WEST SUSSEX COUNTY COUNCIL CONSULTATION

TO:	Arun District Council FAO: Michael Eastham
FROM:	WSCC - Public Rights of Way
DATE:	18 March 2021
LOCATION:	Land to the south of Ford Lane and East of North End Road Yapton BN18 0DS
SUBJECT:	Y/9/21/DOC Approval of details reserved by condition imposed under ref Y/82/20/RES relating to Condition Nos 5 - non-dig surfacing method and 8 - electric vehicle charging strategy.
DATE OF SITE VISIT:	n/a
RELEVANT PUBLIC RIGHTS OF WAY NUMBER(S):	FP357/FP358
RECOMMENDATION:	Advice / No Objection
S106 CONTRIBUTION TOTAL:	n/a

Please note the following comments in relation to the surfacing work on FP358 along the Eastern boundary of the site;

Drawing Title
Sections through public right of way footpath 358 and 359

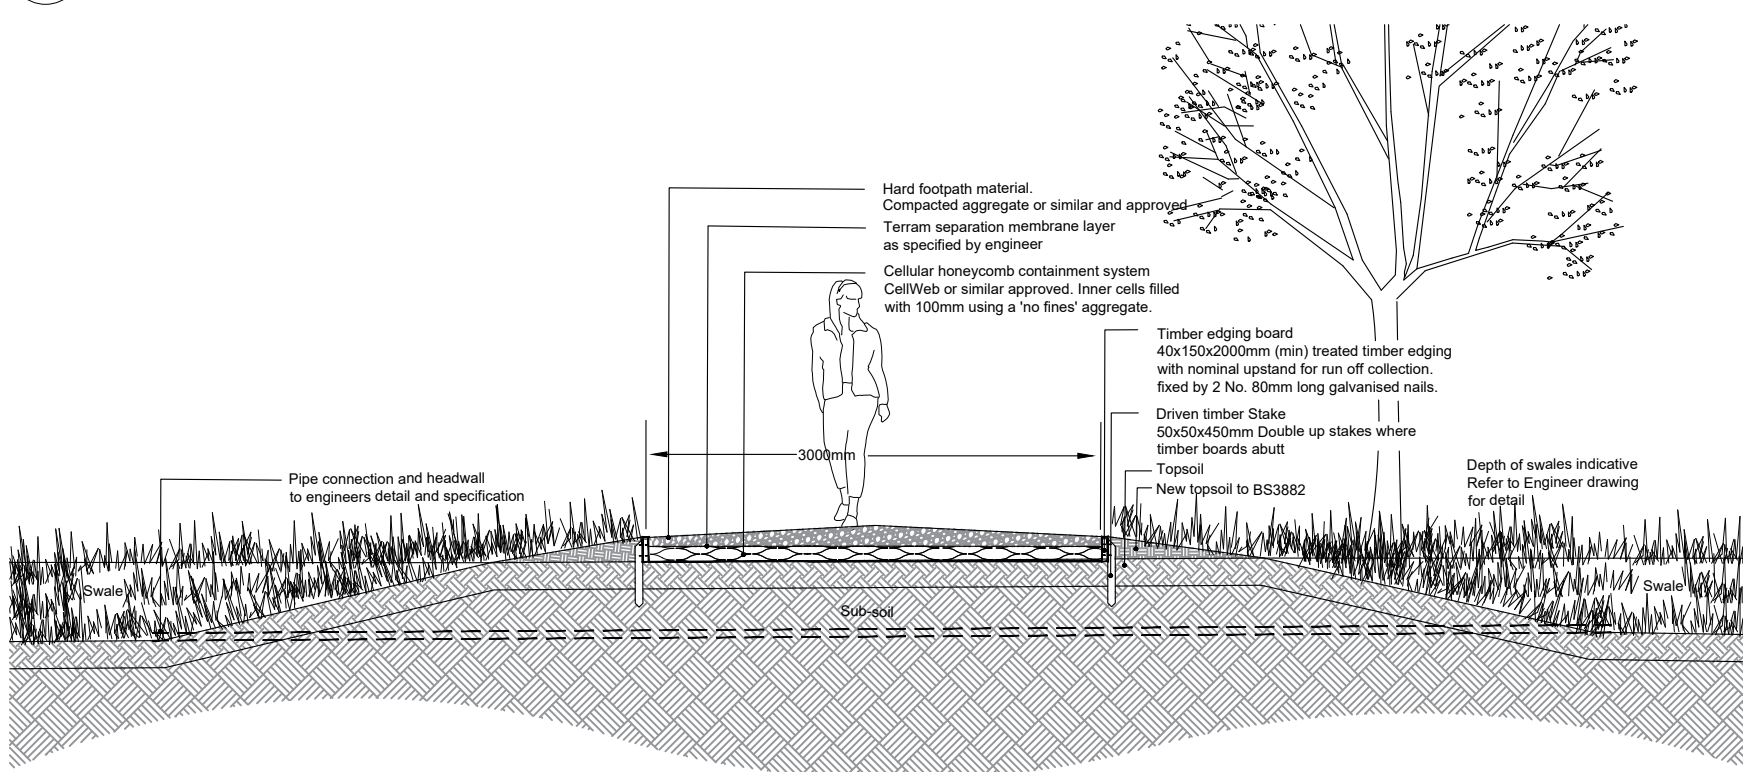
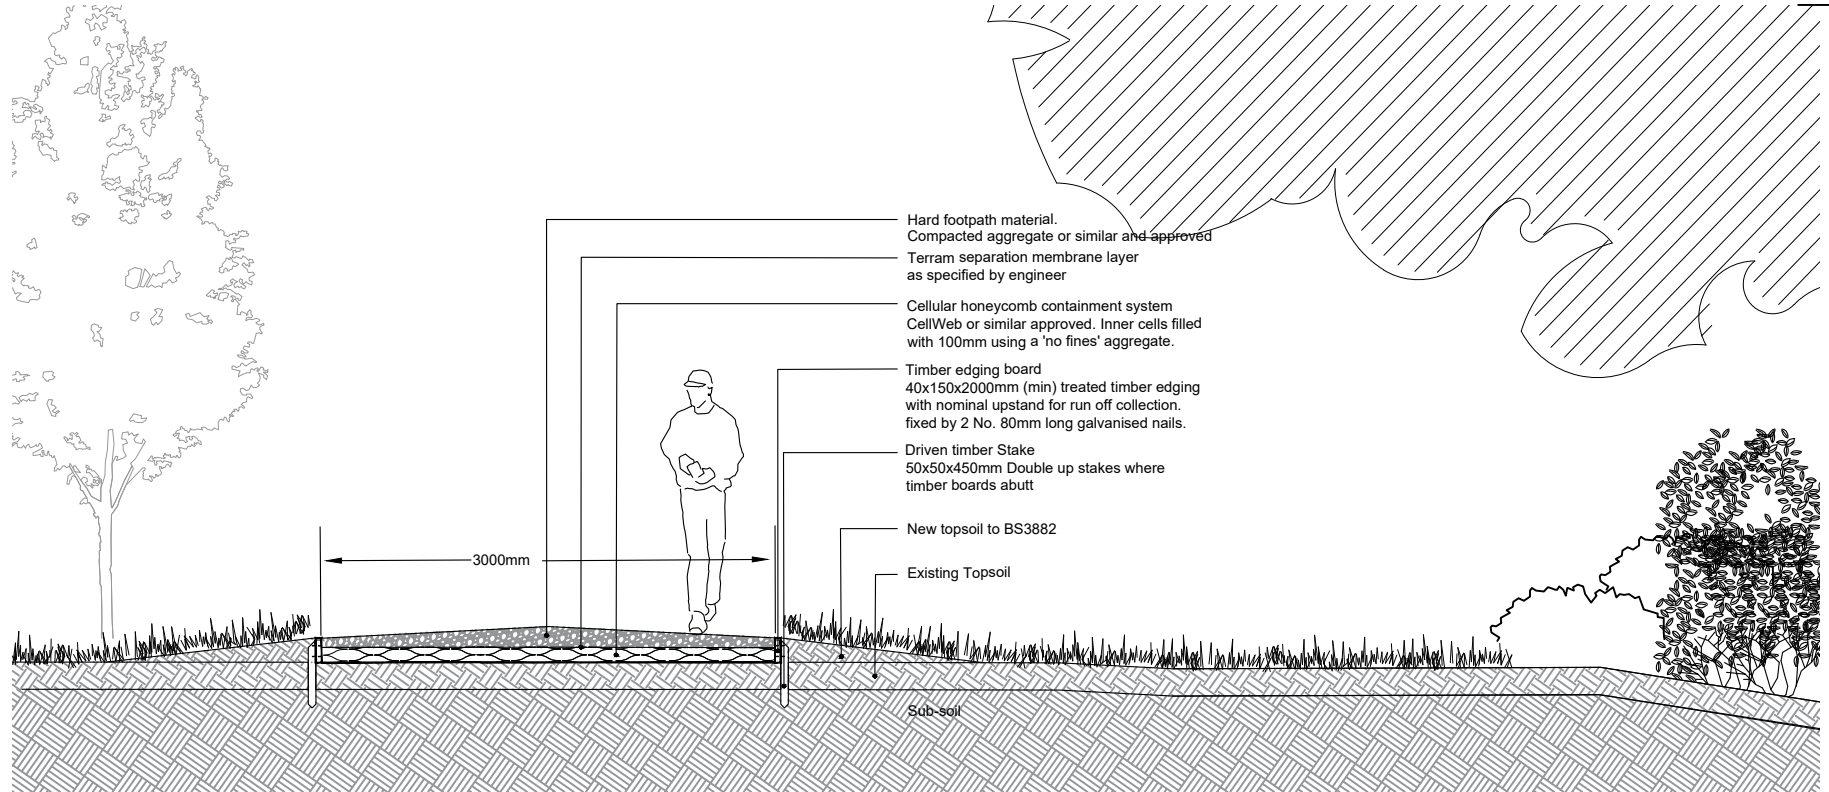
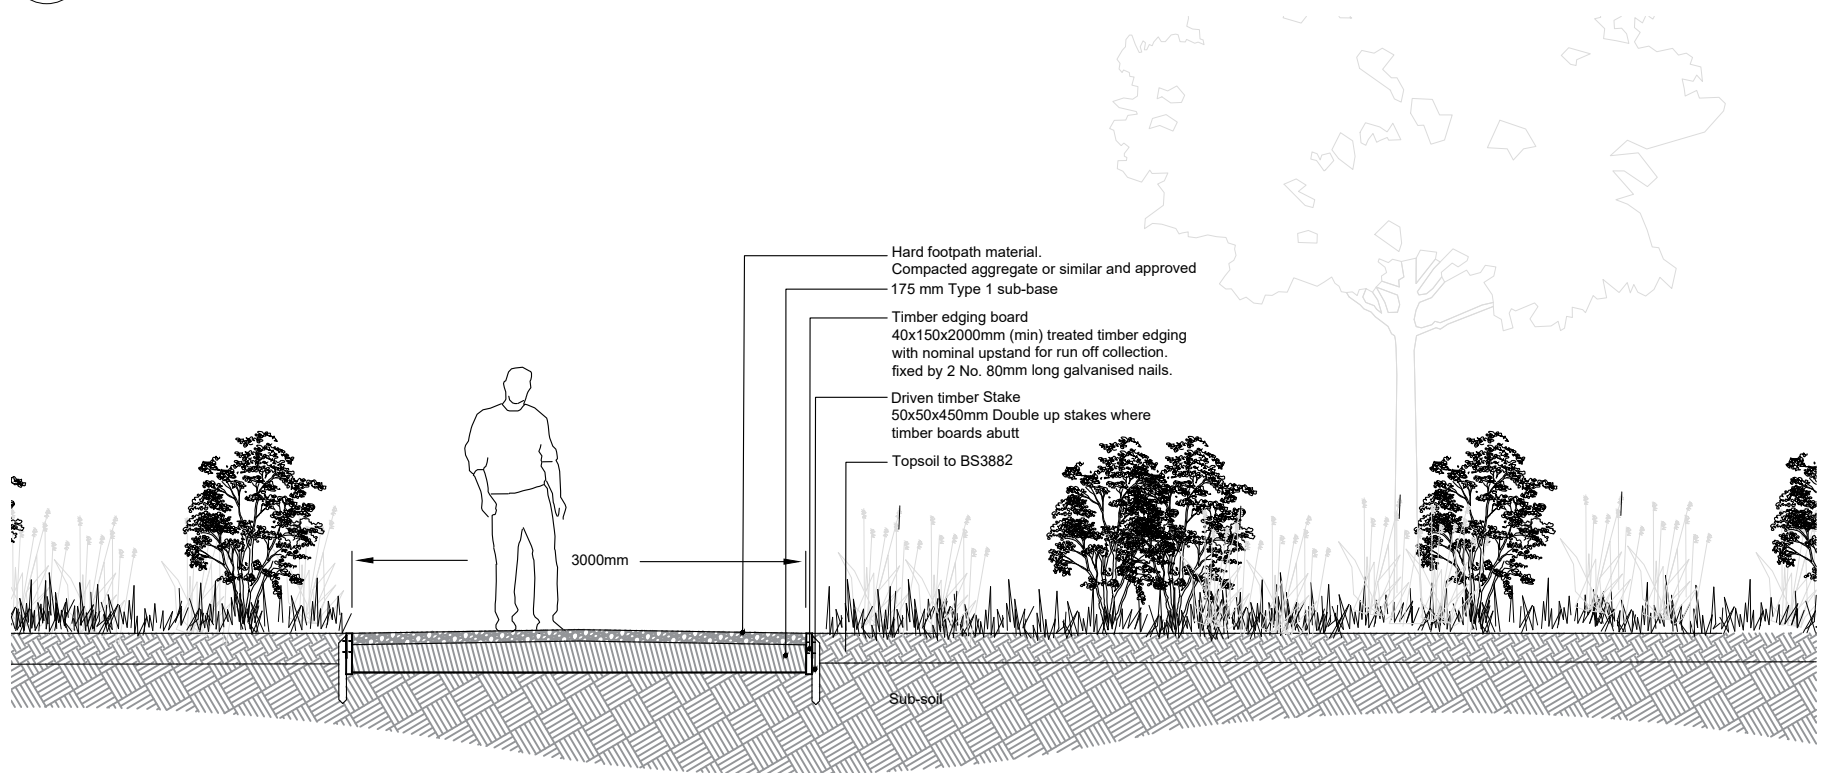
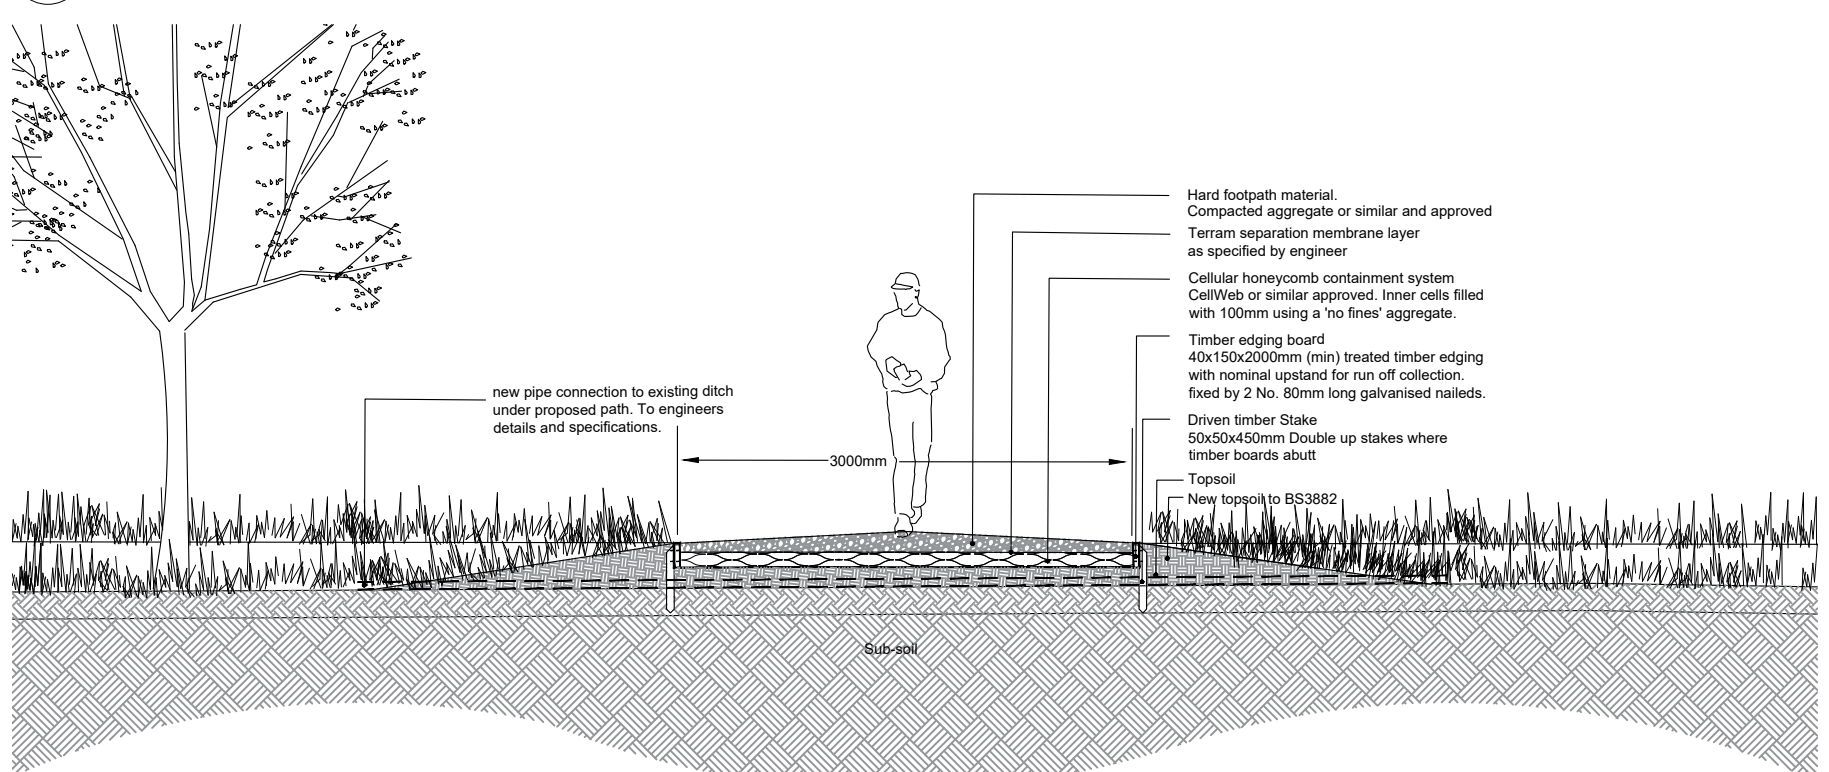
The top dressing depth is not specified in the plans but we would ask this be at a depth of 200mm. The material must be porous / permeable so that water and air can still pass through. Type 1 Limestone or Fittleworth stone is widely used on PRow surfacing.

Similarly the geotextiles used should be permeable to air and water. The geotextile specified by the manufacturer of the cellular confinement system is the one that should be used but it should be a needle-punched non-woven geotextile. The base geotextile (min. 300g/m²) should have a CBR puncture resistance of 4000N. The upper geotextile (below the wearing course) can be the same or slightly thinner (100-300g/m²). The edge supports are important for retaining the wearing course and filling incomplete cells at the edges. Peg and board is fine but make sure that the pegs are every 1m or so (without damaging roots!) to prevent the boards from bowing and that they are slightly proud to retain the surface material. If there are roots very close to the surface or even protruding, obviously the boards will have to straddle these with cut outs and may need some reinforcement in such areas.

Any voids should be infilled to create a level surface with the same angular stone aggregate as used to fill the cells or sharp sand to ramp over protruding roots. Avoid deep layers of sharp sand under geocells because the layers might erode through water movement. It's most important that there's no topsoil stripping to create a level surface
